**Re: LHM Jeep Dodge  
Request for Permanent C.O. - Accepted  
Engineer's Stamp Date 3-31-16 (K19D023)  
Certification date: 2-10-17**

**RE: LHM Jeep  
Grading and Drainage Plan (Stamp Date 3-31-2016)  
Hydrology File: K19D023**

**Cc:** Cherne, Curtis; Harmon Rita T.  
**Subject:** LHM Jeep - K19D023 - Stamp Date 3-31-2016

Albuquerque Standard Drawing 2405B

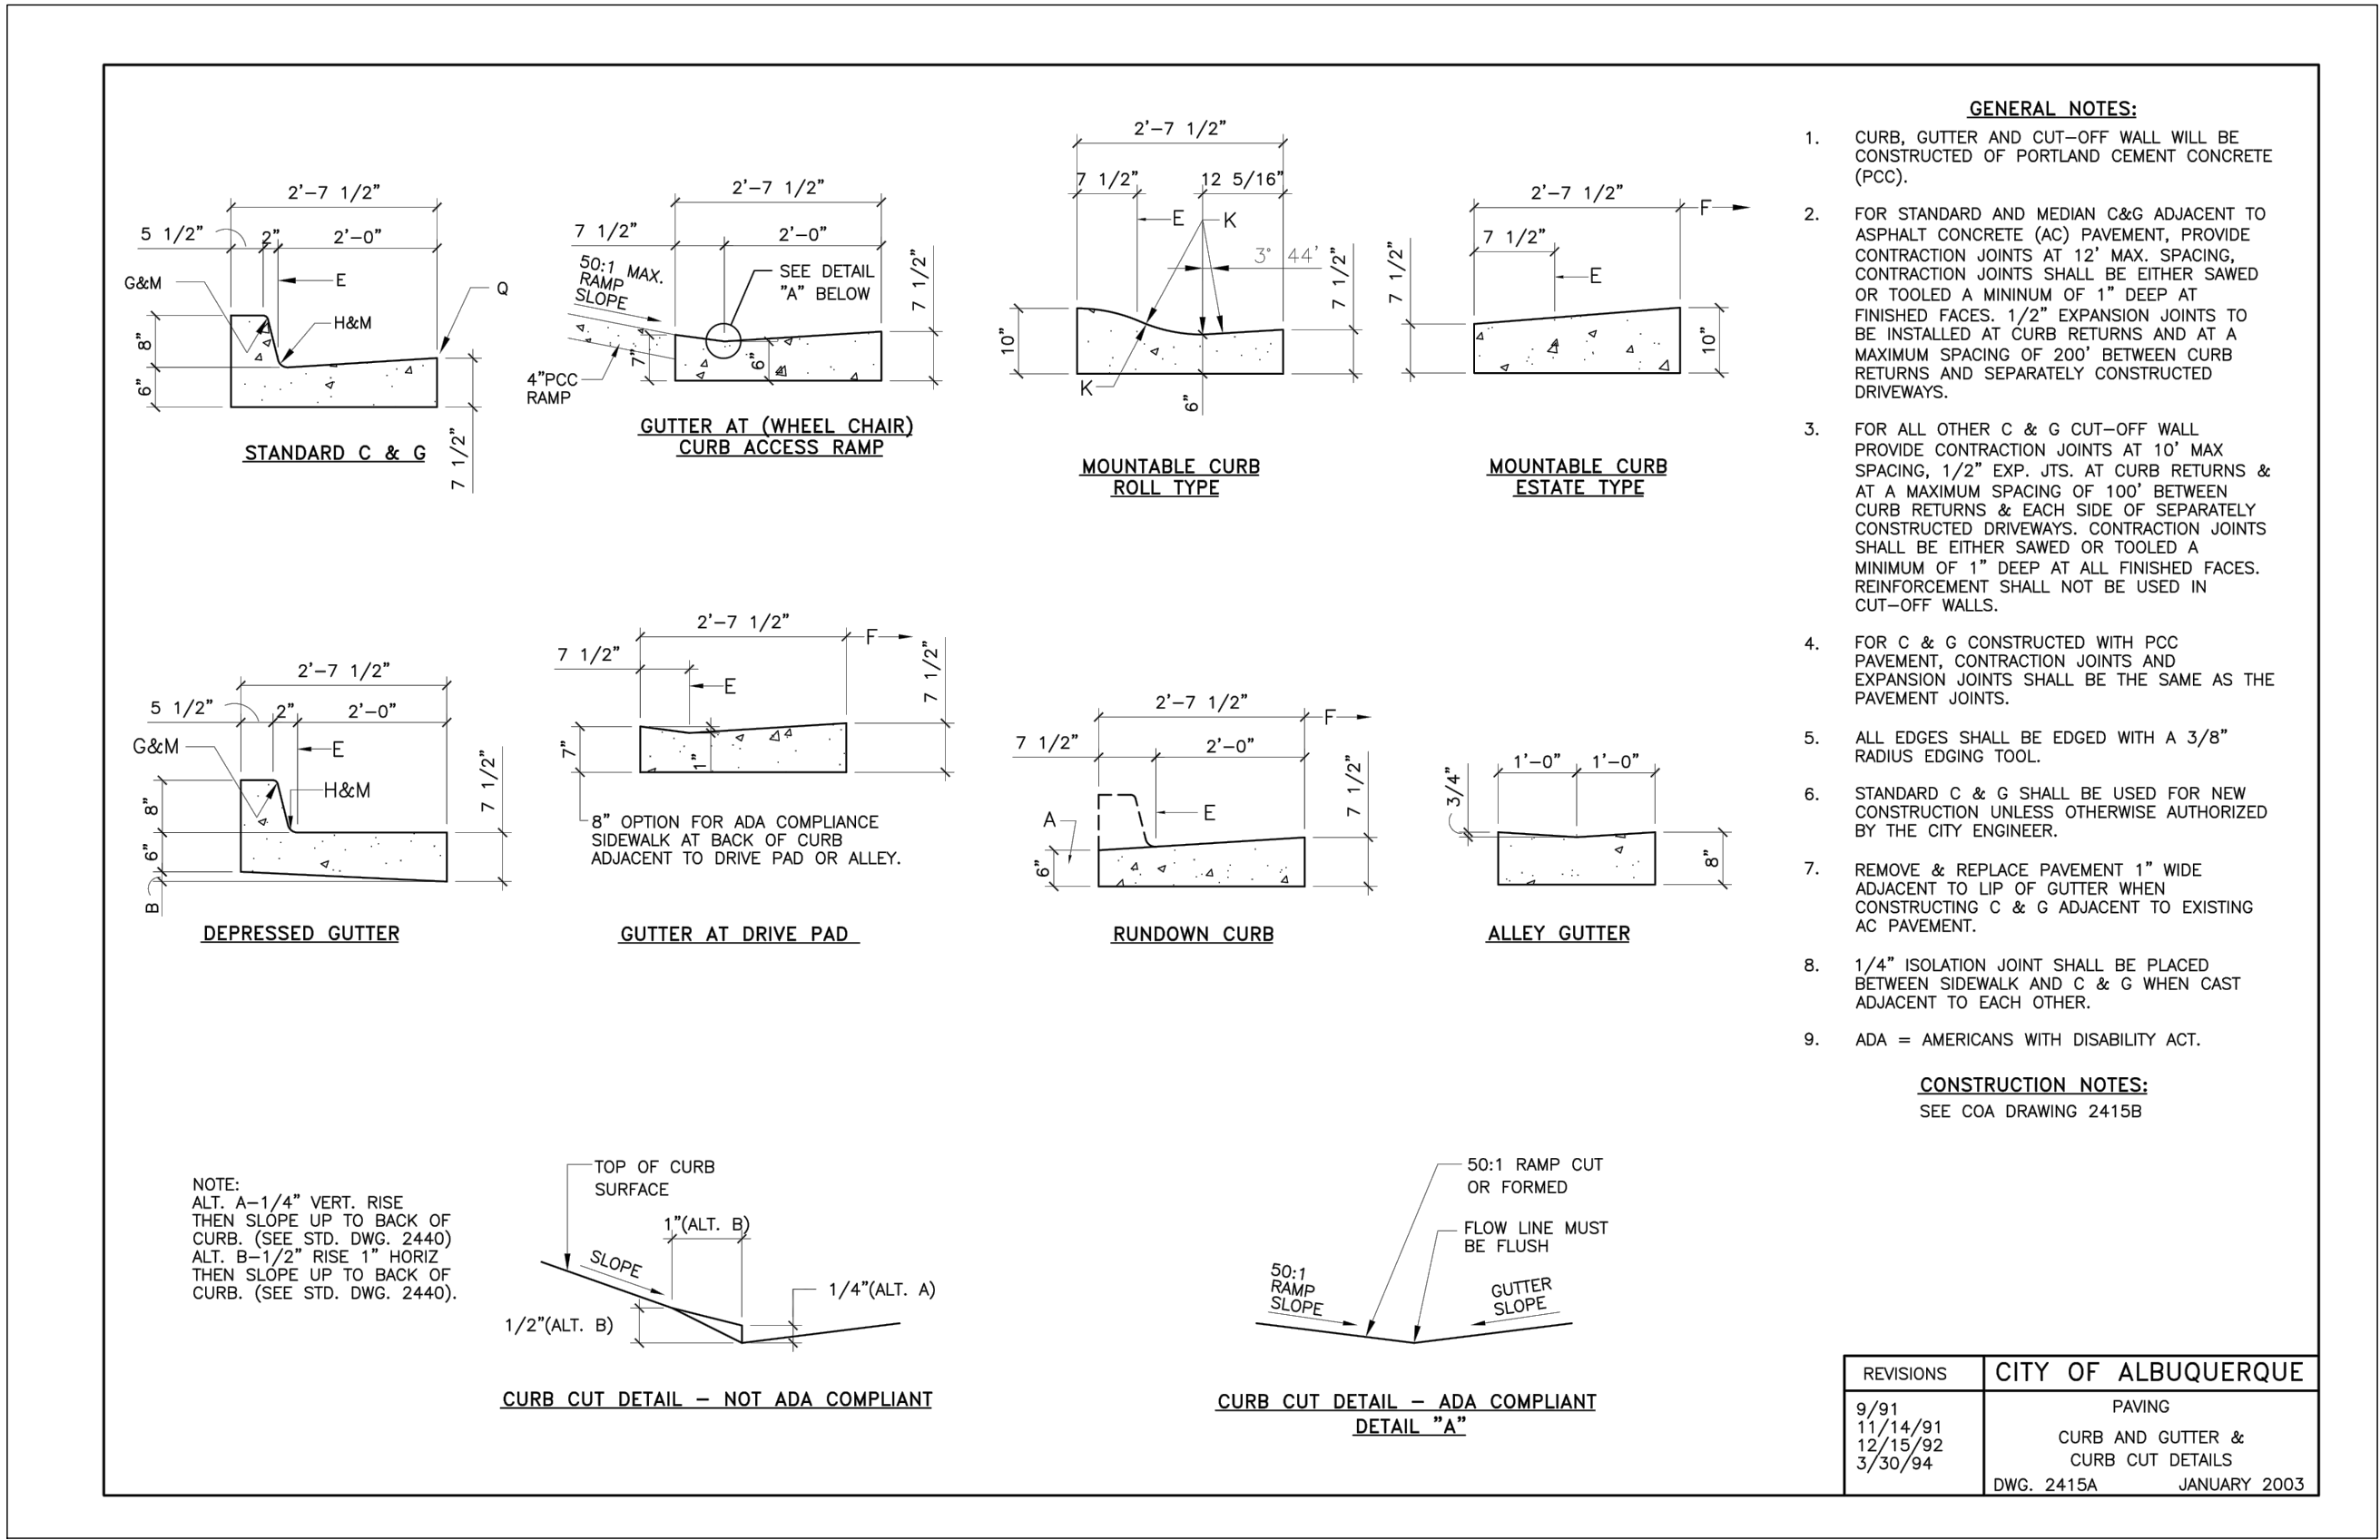
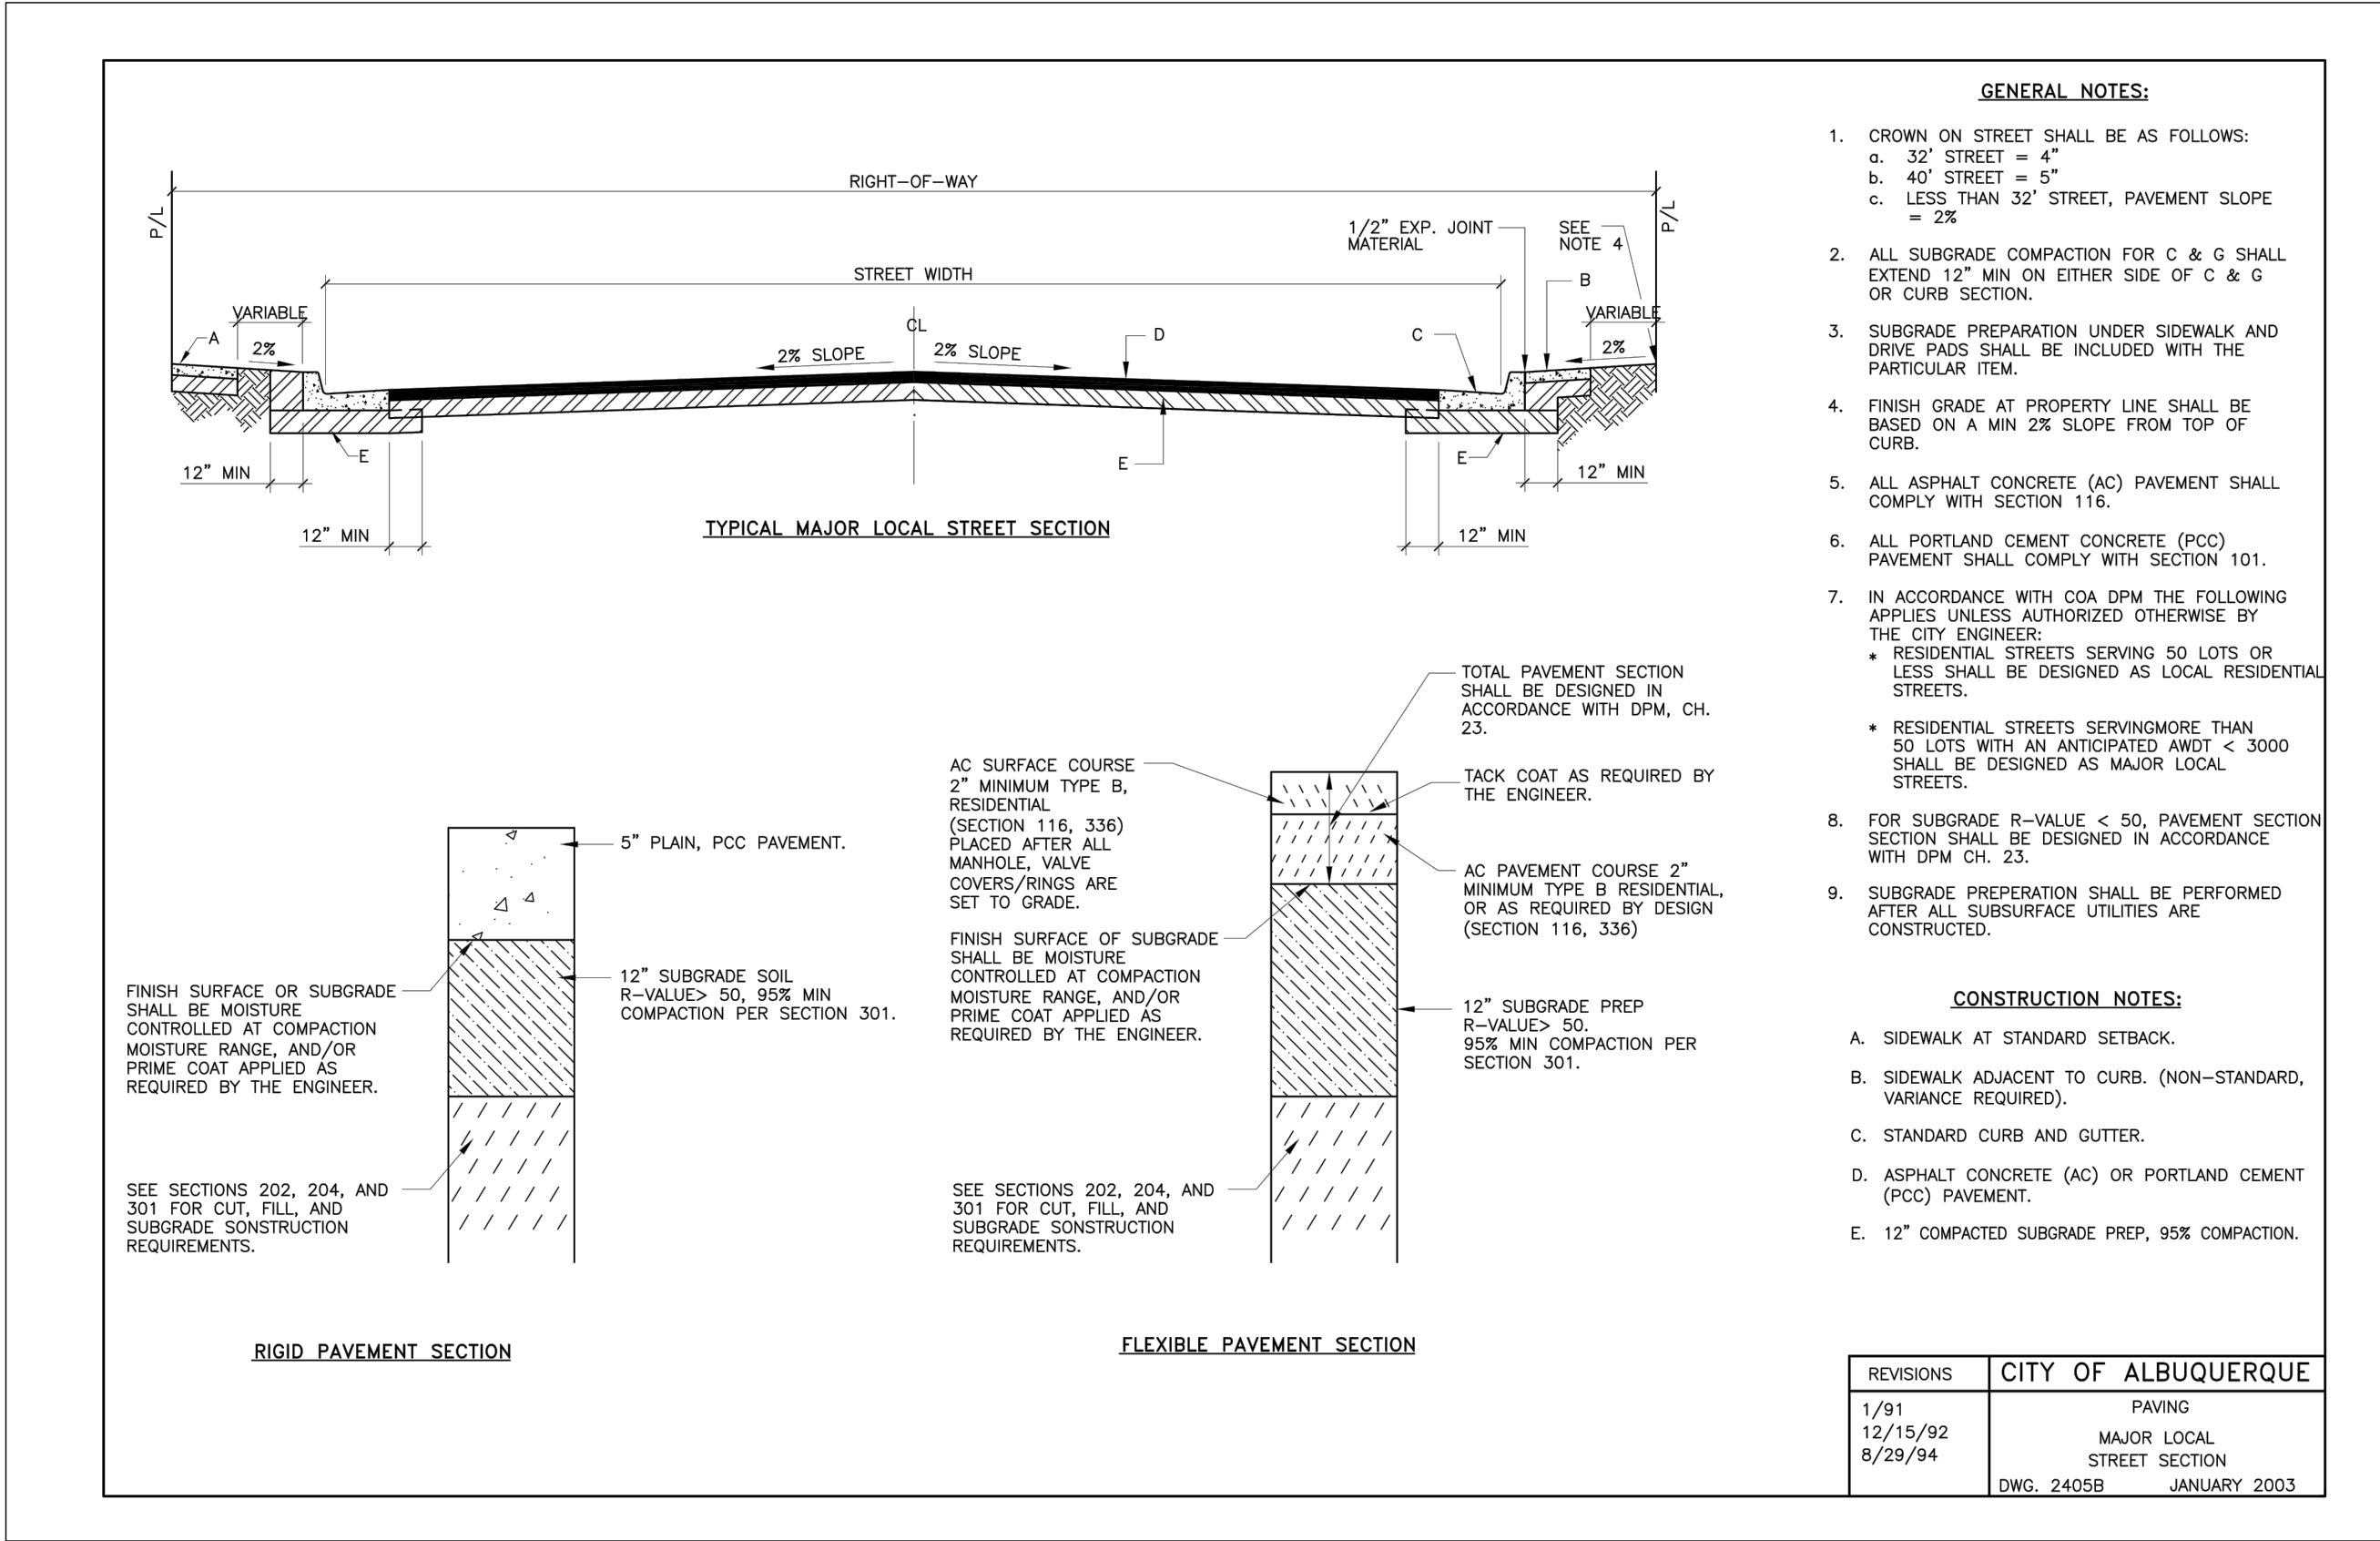
Comment: The City has implemented a new standard drawing for street sections (2405A and B) that shows a depression between the back of curb and the back of sidewalk (for detached sidewalks). In this case, please show a depression between the back of sidewalk and the property line (4"-6" where practicable), to mitigate the storm runoff from the right of way into the property.

Response: Okay, depression added, and detail added to plans.
